St Marys Resource Recovery Facility (Borg) (SSD-10474)
Request for additional information

I refer to Response to Submissions report submitted for the St Marys Resource Recovery Facility (SSD-10474). The Department is requesting that you provide additional information.

Attachment 1

Figure 2.1. Site layout showing processing areas within the facility.

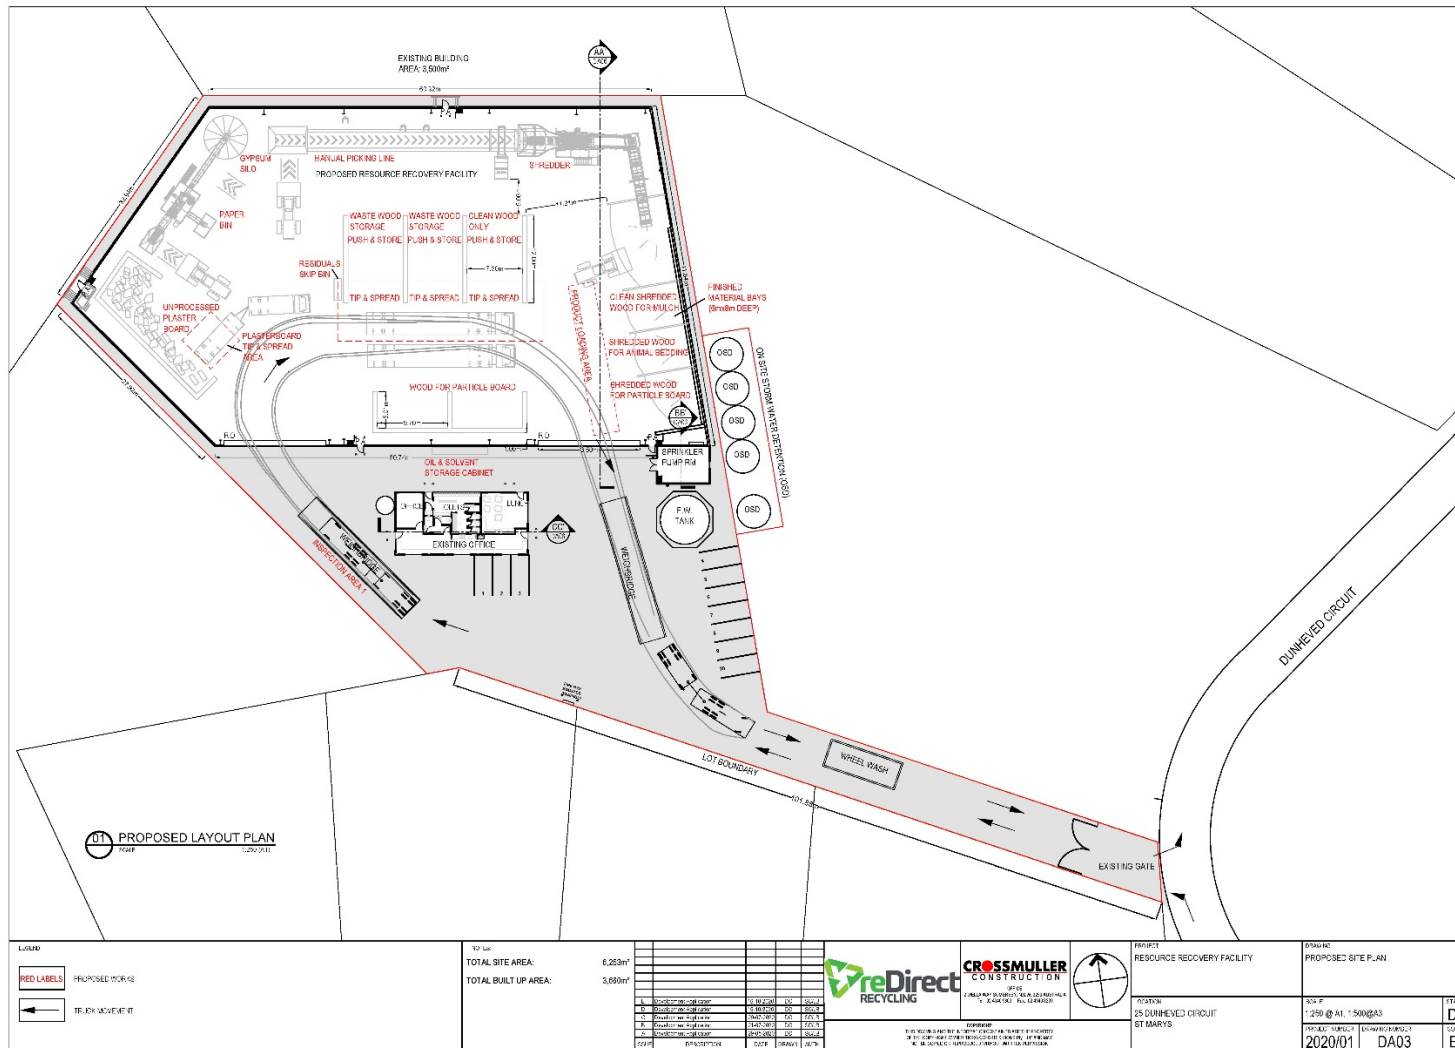
2. The tip and spread area for wood waste shown on the updated plans overlaps the wood waste storage area. This conflicts with Standard 1.2 of the 'Standards for managing construction waste in NSW' (EPA 2019). Please clarify that the tip and spread area can be appropriately located, whilst also maintaining necessary waste storage capacity.

4. Section 6.4 of the Non-conforming Waste Procedure identifies that non-conforming waste may be moved to a bunded area prior to removal. Please clarify the location of this area on the plans.
